Land north of
CAMP ROAD

HEYFORD PARK

DESIGN AND ACCESS
STATEMENT ADDENDUM

July 2022

## Landscape and Open Space

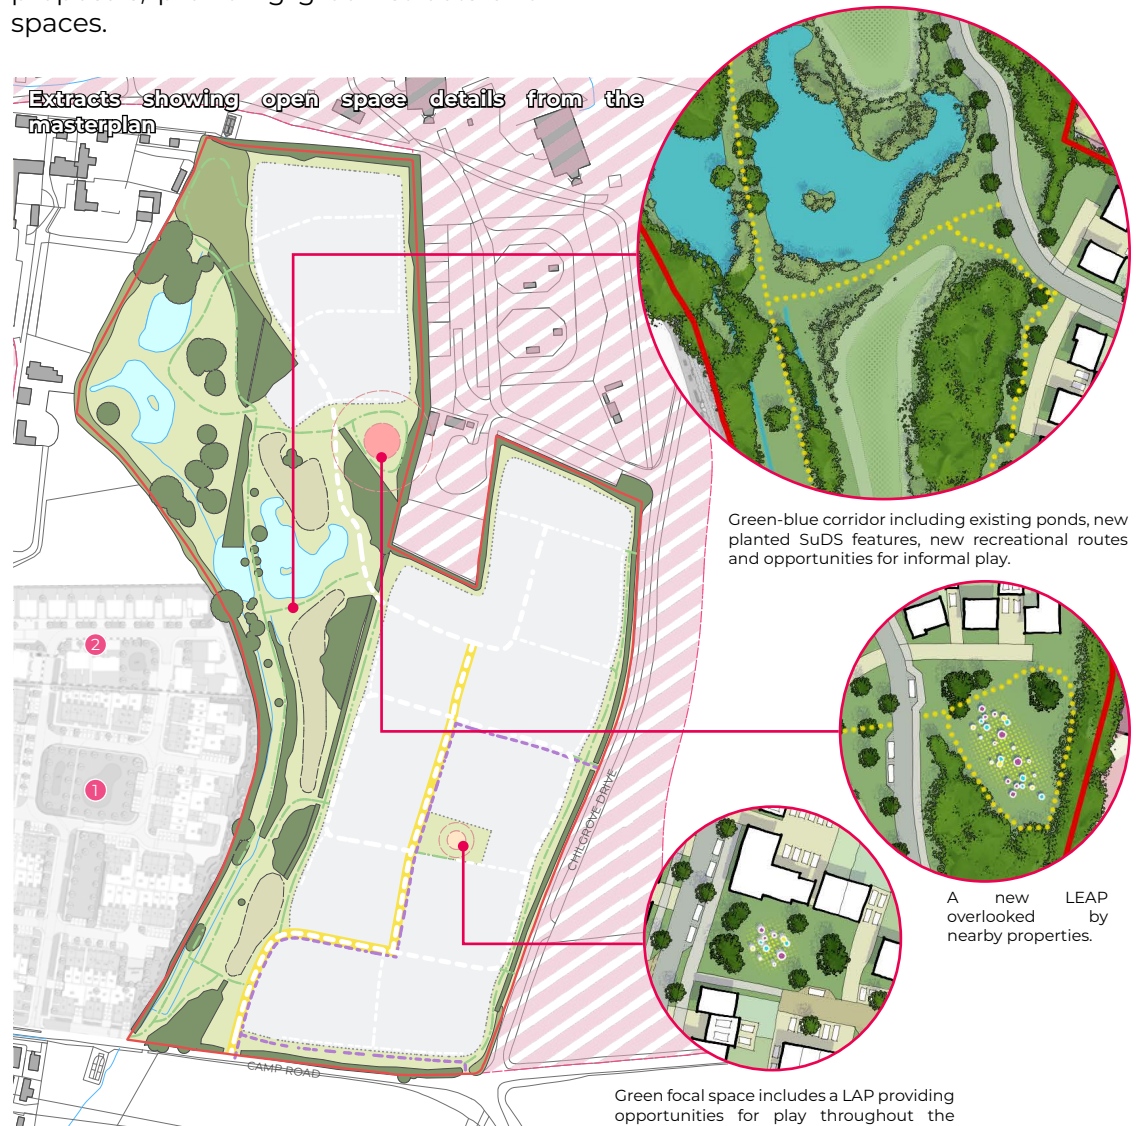
The Landscape and Open Space Parameter Plan has been updated to reflect the new proposed NEAP and the reshaped attenuation basin.

The NEAP has been located close to the LEAP, providing convenient access for all residents. Both the NEAP and LEAP are positioned with sufficient buffers to residential development. The attenuation basin has been reshaped to accommodate the NEAP and existing trees, fitting within the green infrastructure without needing to adjust the development footprint.
